**KIRKLEES METROPOLITAN COUNCIL  
INVESTMENT & REGENERATION SERVICE**

**DELEGATED DECISION TO DETERMINE PLANNING APPLICATIONS**

| Reference No:         | <b>2024/62/93338/E</b>                                 |
| Description:          | Erection of two storey side extension with front porch |

PROPOSED

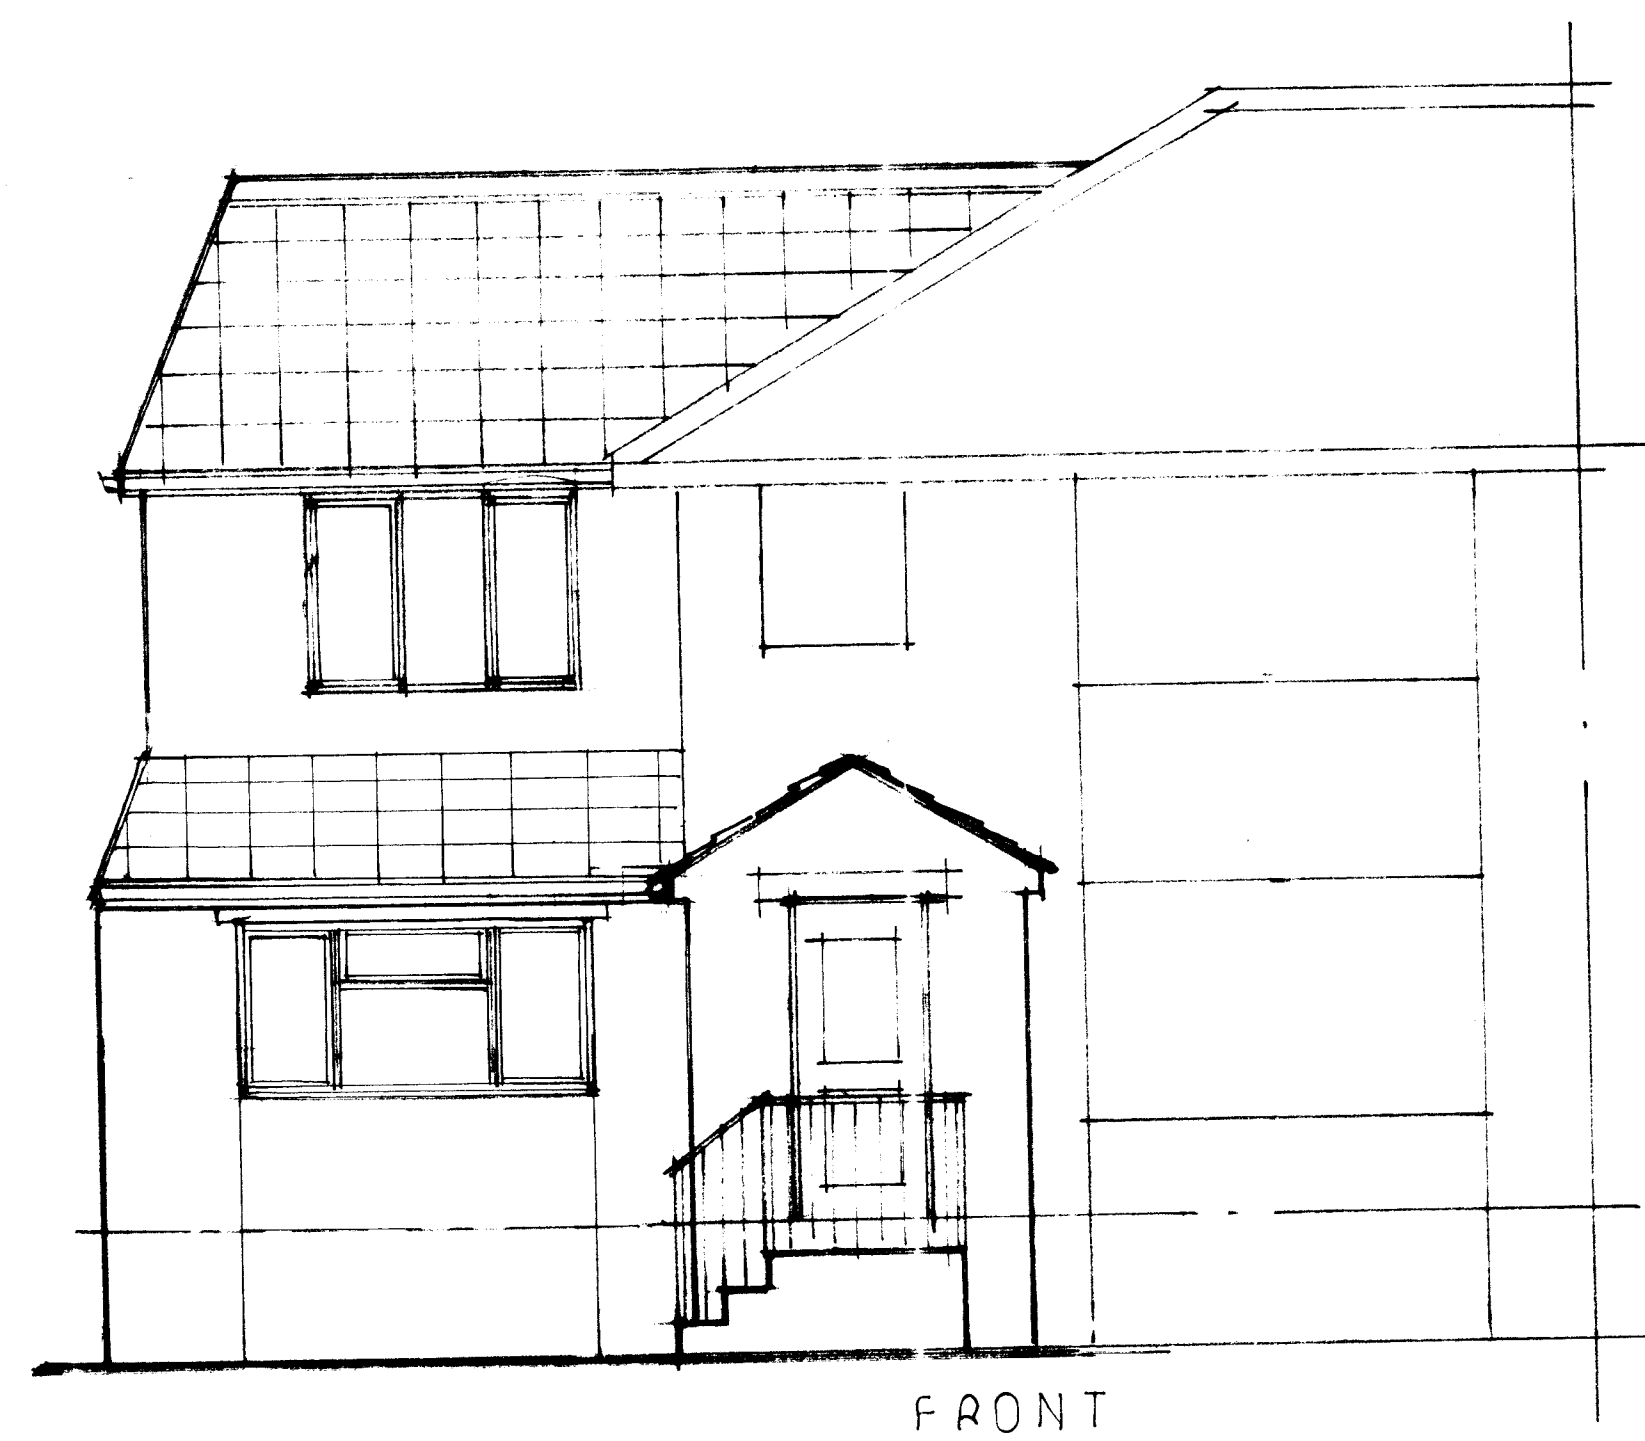
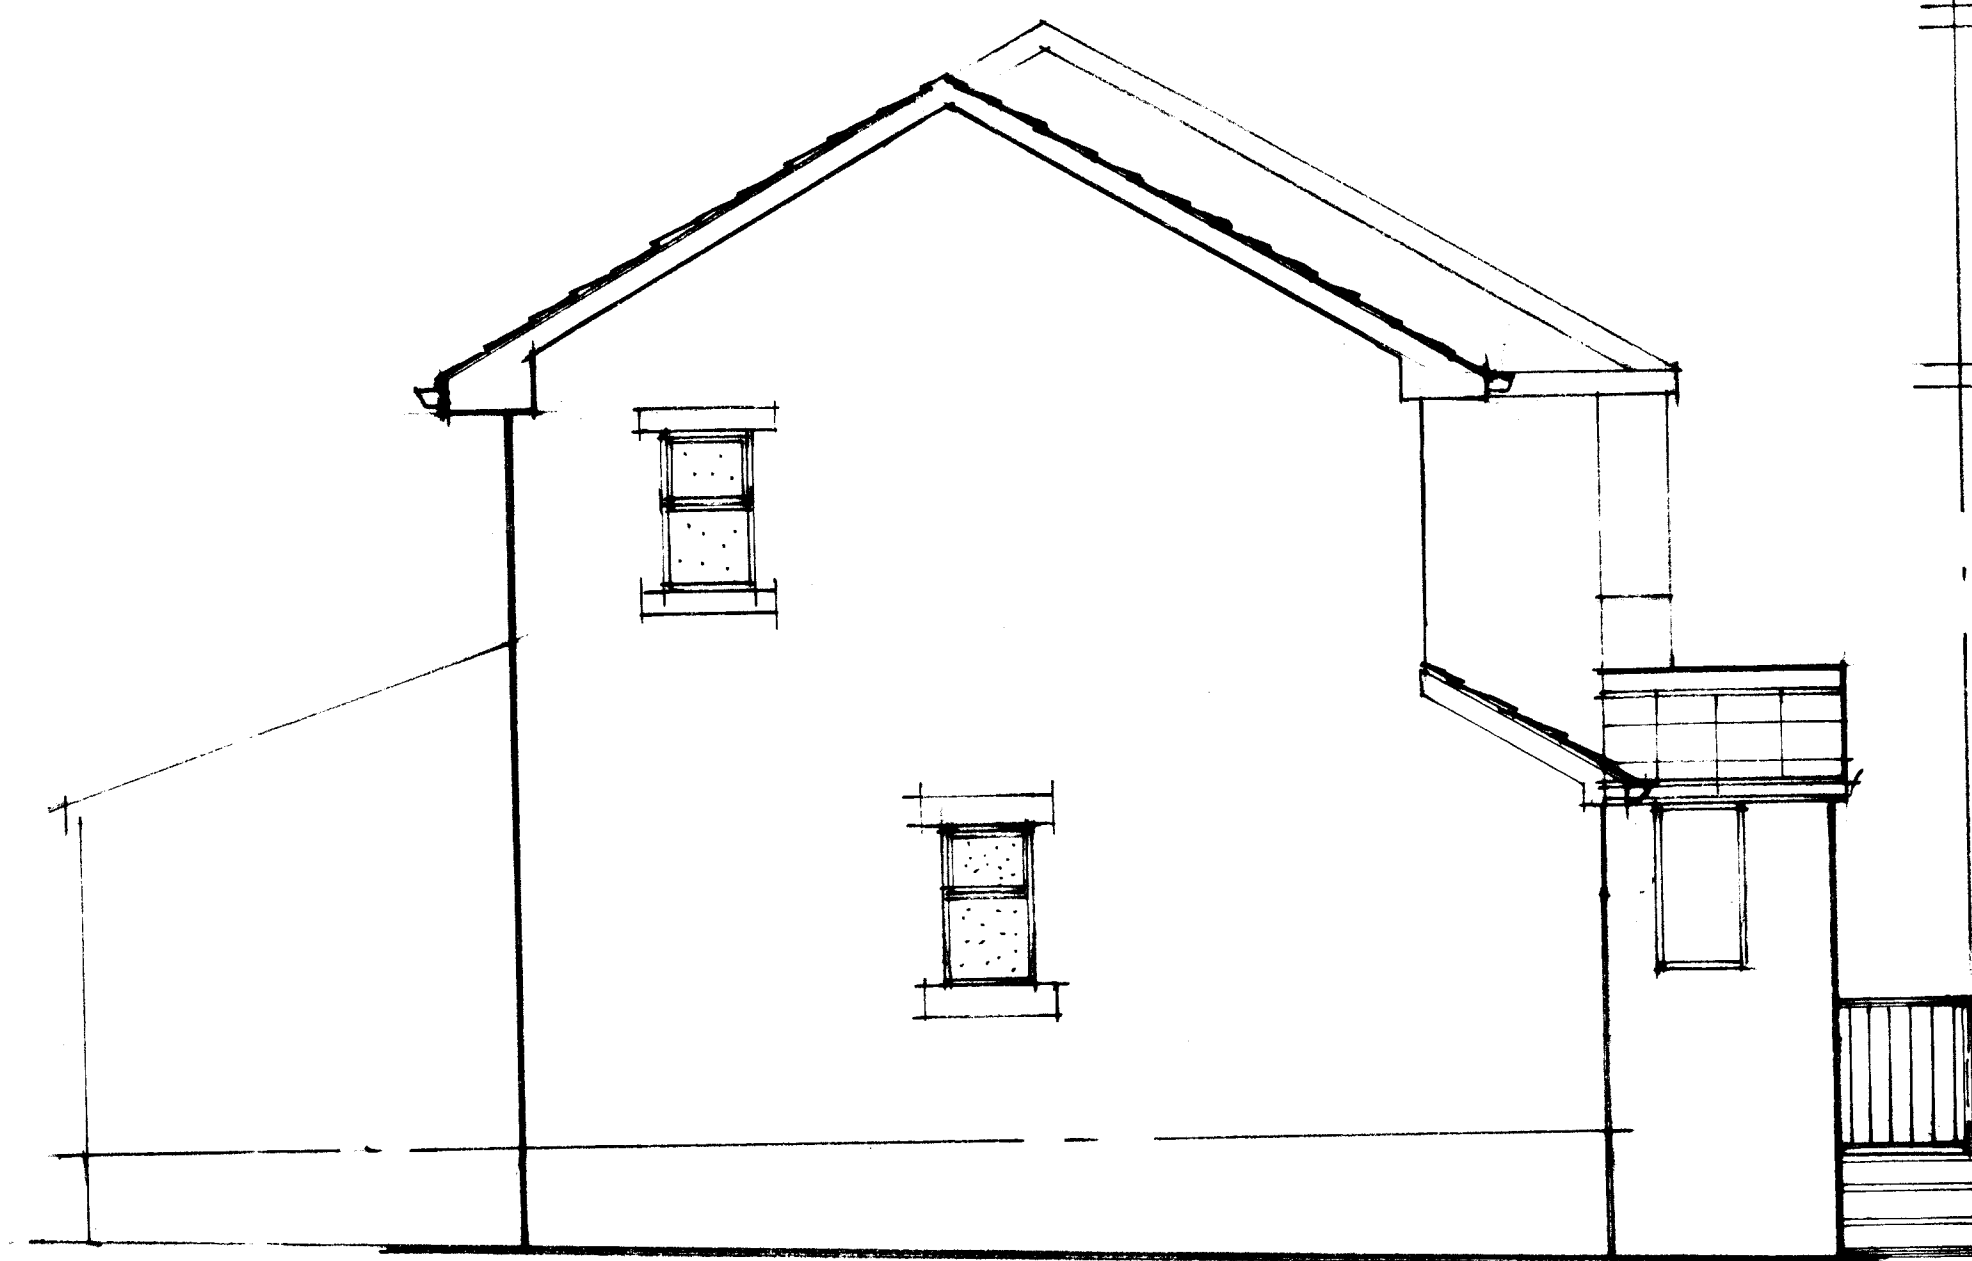
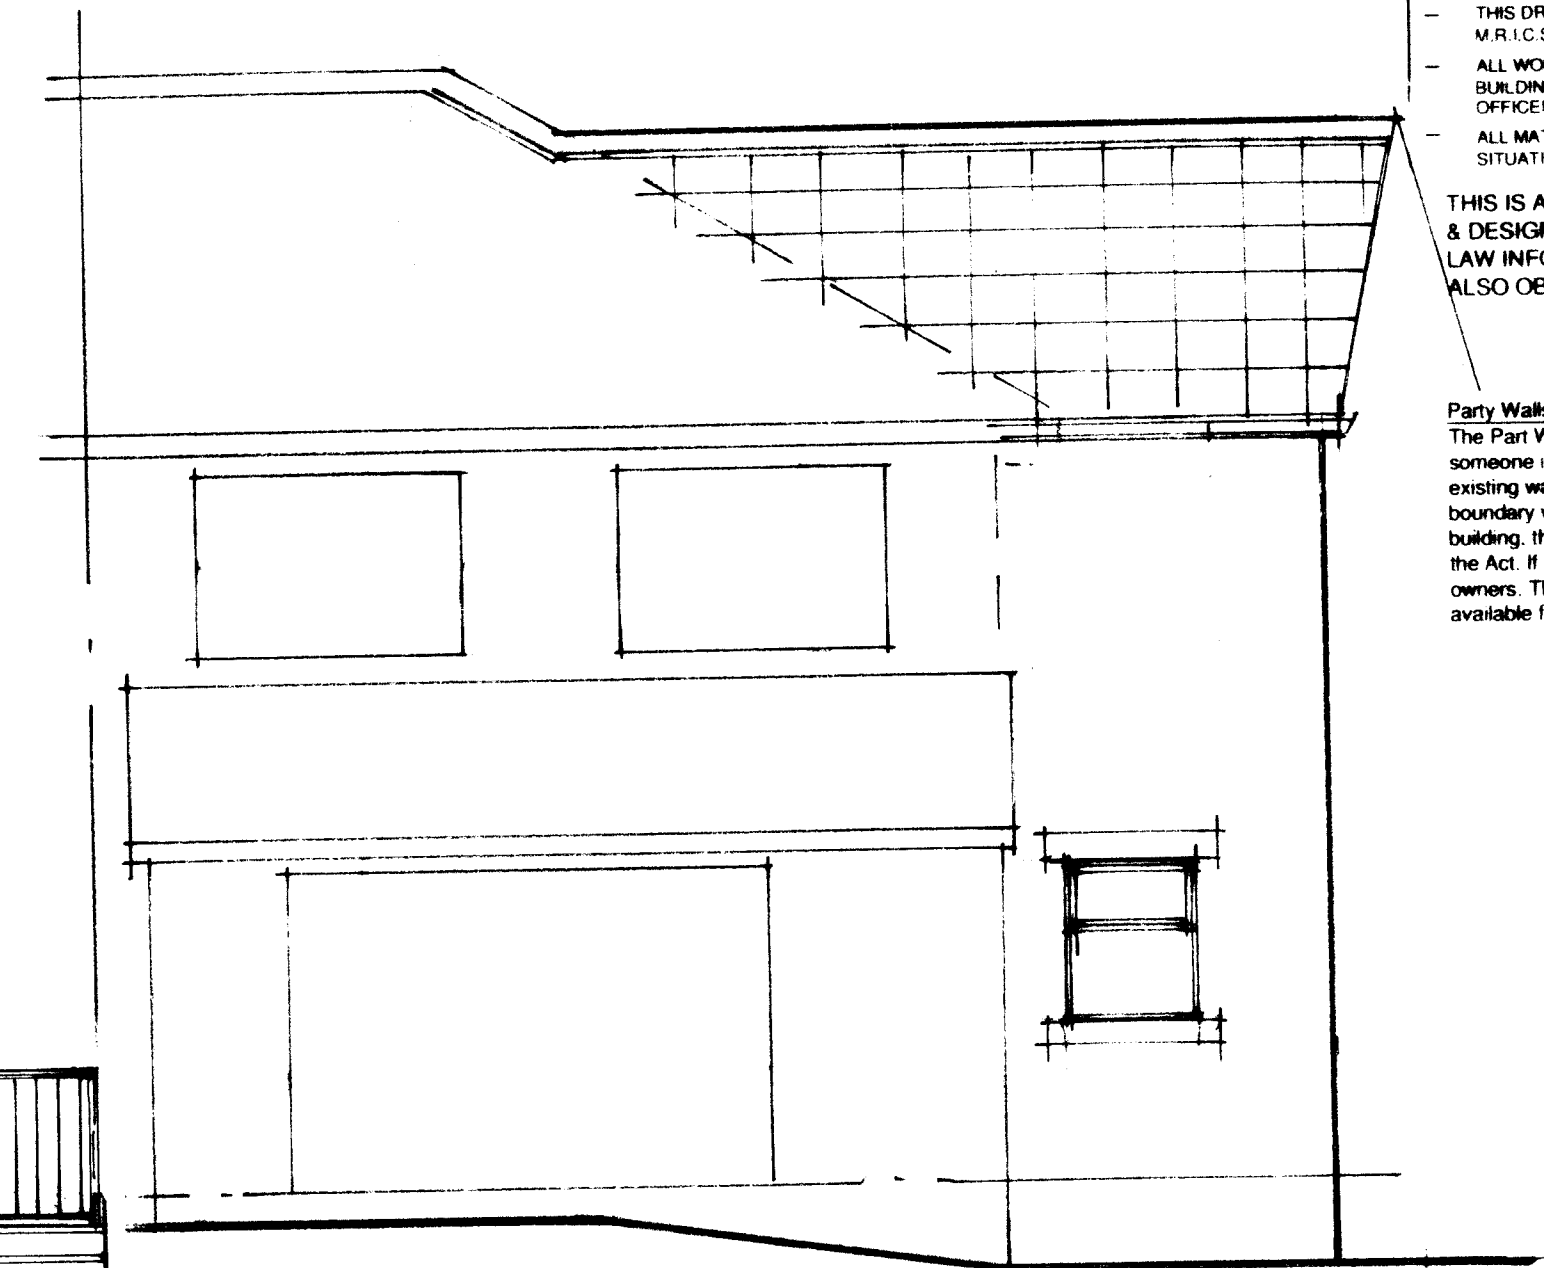
The side extension would project 3.8m from the original side wall at the front corner of the property, tapering to a lesser projection to the rear and angling 1m from the side boundary. The first floor would be set back 1m. The roof over the single storey element would be lean to with a hipped roof over the first floor.

The proposed porch would be of a small scale and acceptable design, and it is noted, would be viewed in the context of the front extension at the adjoining property.

The side extension would be set back from the front elevation of the dwelling with the roof form being set down for the main roof and a gap would be retained to the side boundary. The side extension would be proportionate to the main house. The scale and design are therefore considered to be acceptable. The materials proposed include the use of brick for the walling with tiles for the roof covering which would match the main house. The side extension is therefore considered to be acceptable in terms of visual amenity.

The adjacent property is bungalow with limited openings and which are secondary/non-habitable in nature. Given the spatial relationship, which is angled, and the alignment of the properties, the proposed side extension would have limited potential to result in any overshadowing, overbearing or overlooking. The porch, due to its design and location would also not result in any detrimental impact on residential amenity

The extension proposed would be located on the opposite side of the host property to the adjoining dwelling and as such would have no impact on the amenities of the occupiers of the adjoining dwelling in terms of overshadowing, overbearing or overlooking. The porch, due to its design and location would also not result in any detrimental impact on residential amenity.

The initially submitted plans raised concerns in terms of the roof form proposed being out of character with the main house. Amended plans have been sought and received which altered the roof form to a hipped roof. As the alterations reduced the level of development, the amended plans have not been advertised.
